From: Daun Johnson
Sent: 12 April 2018 09:28
To: Planning Scanning
Subject: FW: Further Information Required on Your Ref: PP-06805727 Our Ref: K/10/18/HH

From: Haydn Jones [REDACTED]
Sent: 11 April 2018 11:58
To: Planning.Responses
Cc: 'Gonçalo Diniz'
Subject: RE: Further Information Required on Your Ref: PP-06805727 Our Ref: K/10/18/HH

Elevations as existing

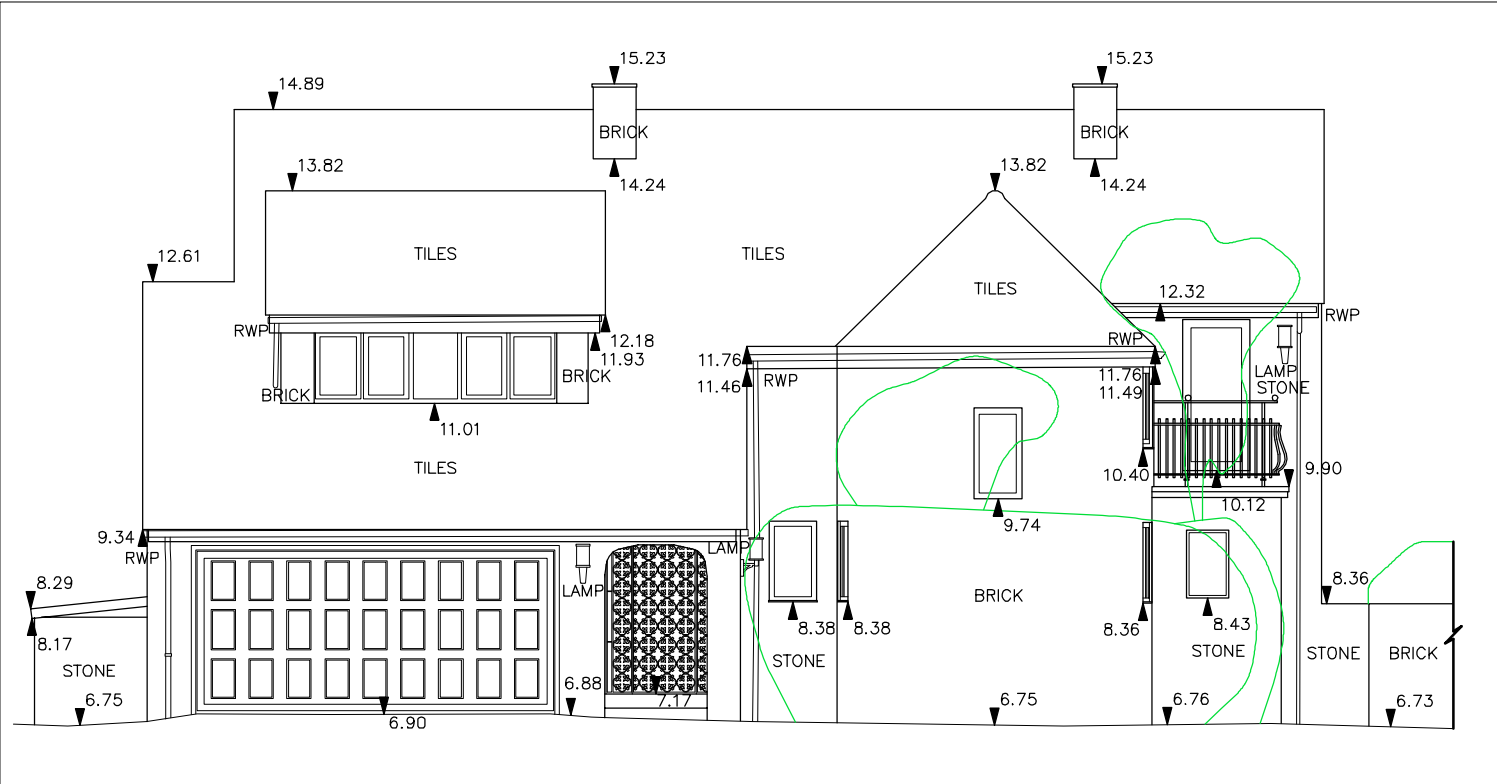
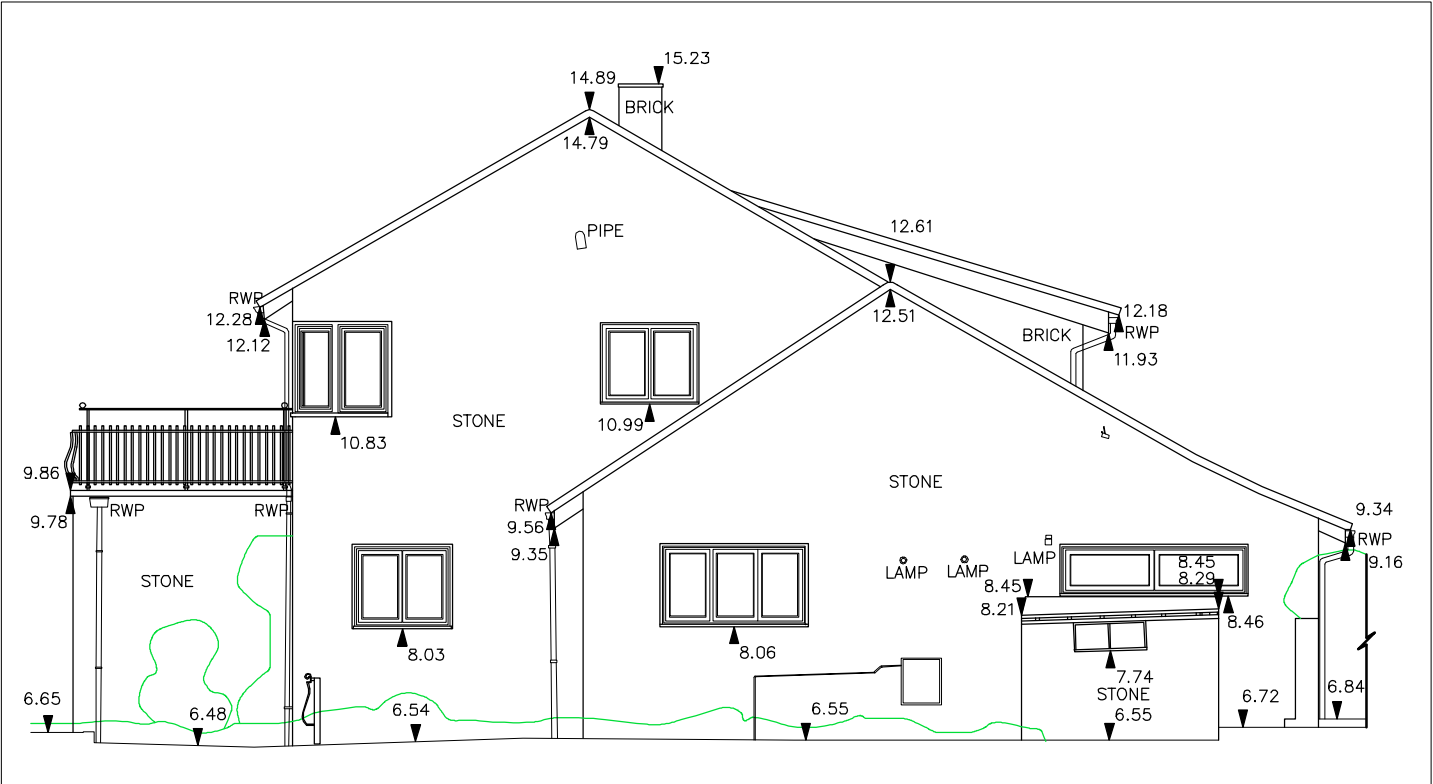
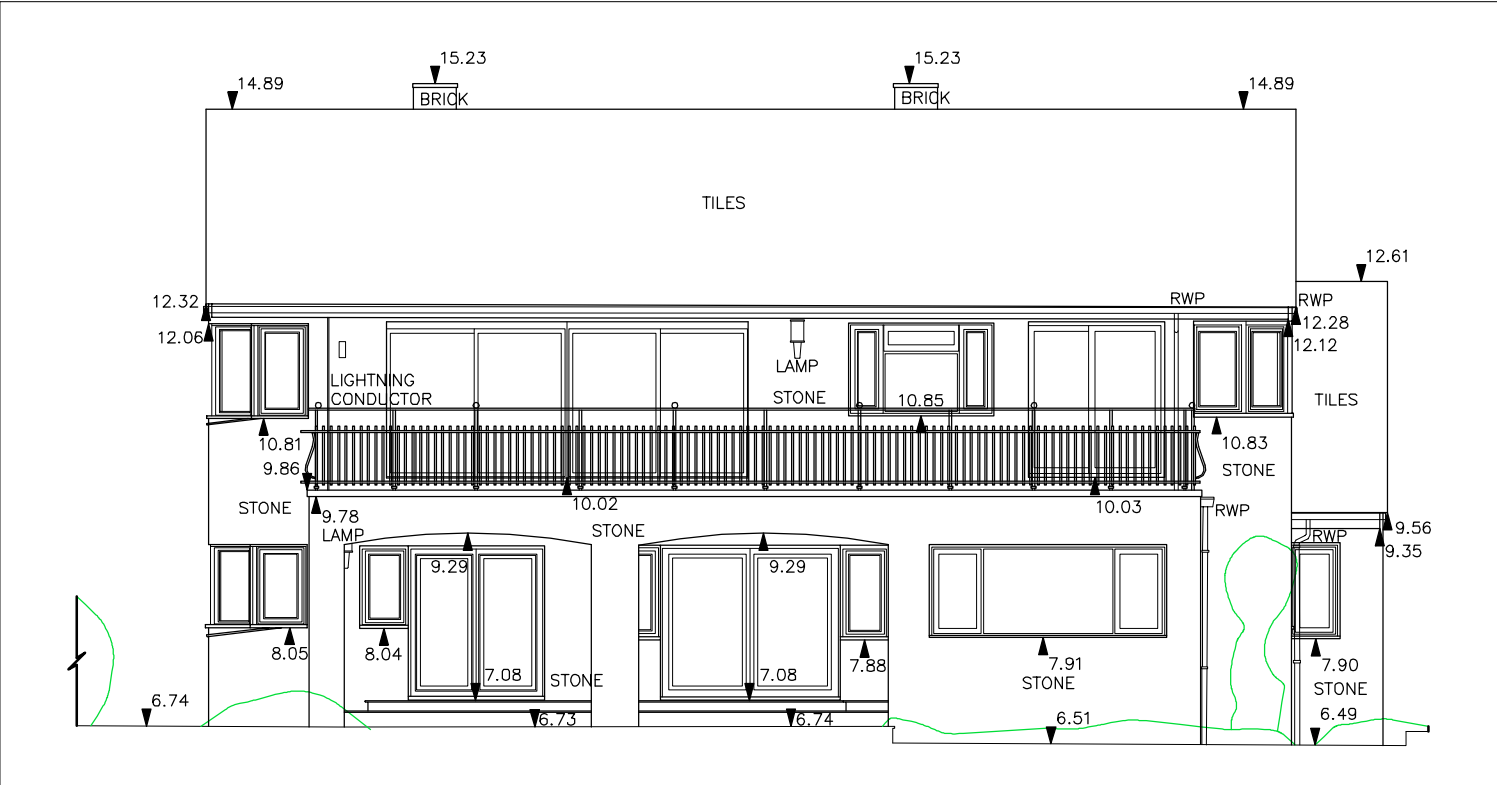
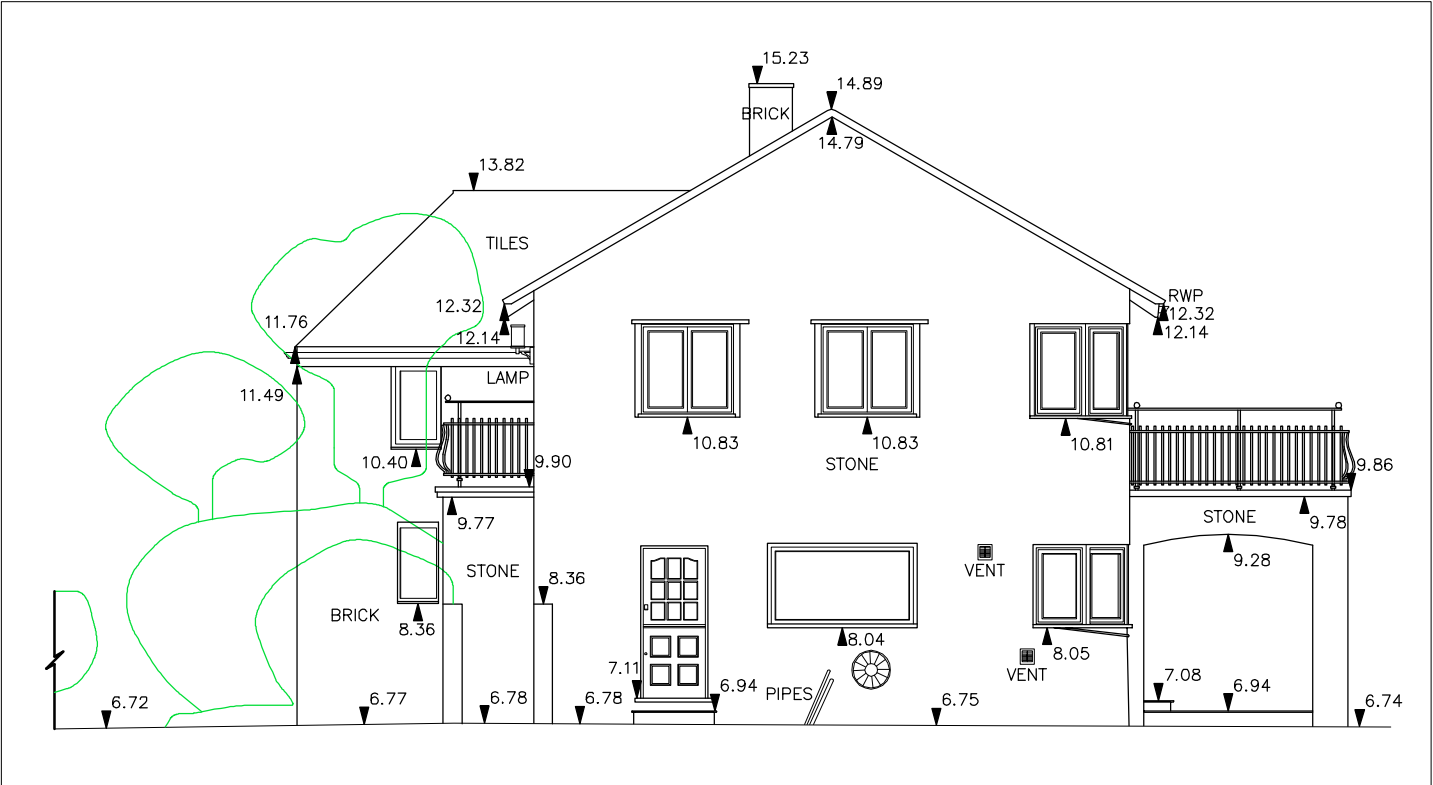
1. As a swimming pool is allowed under permitted development rights, it will not form part of the application.
2. We believe the existing survey drawings plans and elevations are accurate. The window indicated on the semi-circular staircase is located at a half landing, drawing convention would show a landing at ground floor together with the associated window. I am surprised such an anomaly is preventing the validation of this application.
3. A section of the pool will not be provided in this instance as the pool is not part of the application, refer to note (1) above.
